Rezoning Transportation Analysis

Petition Number: 2020-111

| Date | Description |
|------------|--------------------|
| 09-10-20 | First Review (KP) |
| 10-19-2020 | Second Review (KP) |

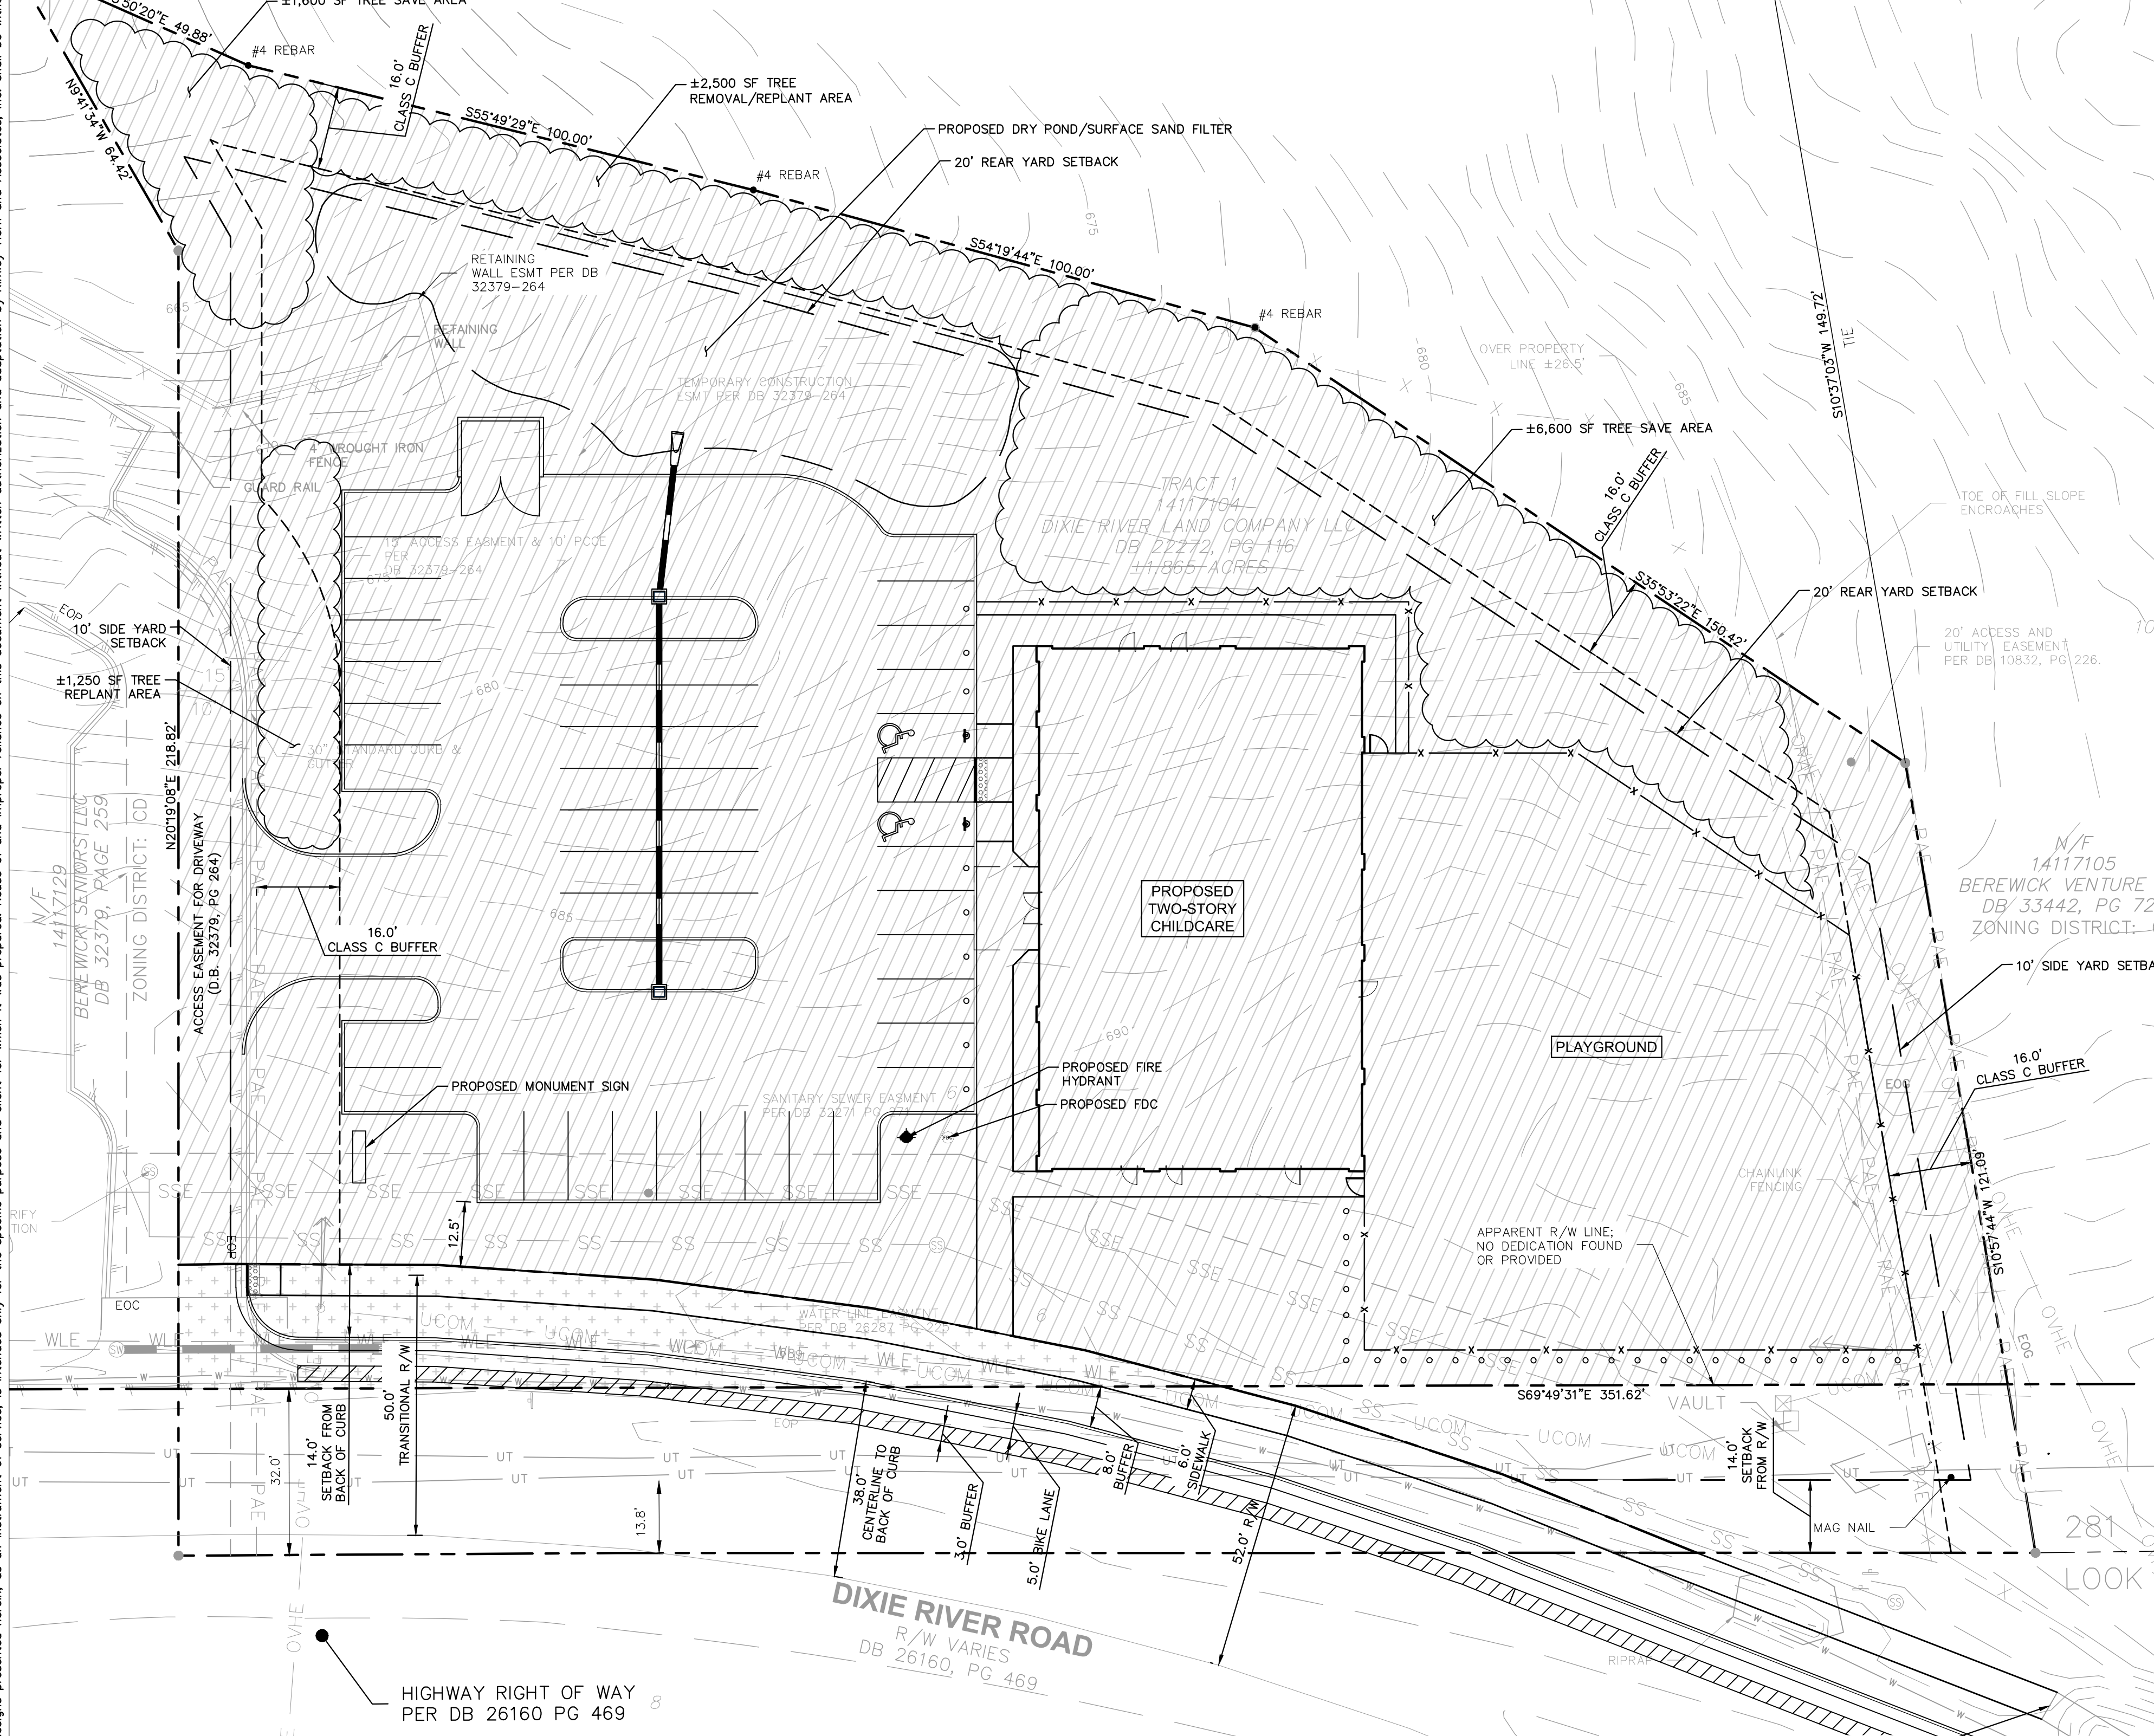
- a. ~~Dixie River Road:~~ Update location of curb and gutter 38-feet from center line to back of curb.

Label and dimension curb and gutter from the center line for each road.

4. Commit to construct an 8-foot planting strip, and 6-foot sidewalk on Dixie River Road and connect to the sidewalk constructed as a part of the Berewick Senior Apartments development, as required by City Ordinance. This should be shown on the site plan, labeled and dimensioned from the back of curb and gutter, as well as noted in the conditional notes.

5. The petitioner should revise the site plan and conditional note(s) commit to construction of a 5-foot bike lane with a 3-foot buffer along Dixie River Road, labeled and dimensioned from the road centerline.
6. Commit to the removal of the existing obsolete driveway(s) in and near the southeast corner of the property. **Update to Comment from 10-12-2020 Site Plan: Please include in the conditional notes.**

7. Site plan needs to show the vehicular movement for daycare pick-up and drop-off to clarify how this process will occur.
8. Add the following conditional note: For street and pedestrian lighting recommendation, coordinate with Anthony Mendez, CDOT. Please visit the following link: <https://charlottenc.gov/Transportation/Programs/Pages/StreetLighting.aspx>
9. Add a note specifying dedication and fee simple conveyance of all rights of way to NCDOT before the site's first building certificate of occupancy is issued. CDOT requests right-of-way set at 2' behind back of sidewalk, where feasible.
10. Add a note specifying a recorded cross access easement with the shared access drive for the Berewick Senior Apartments.
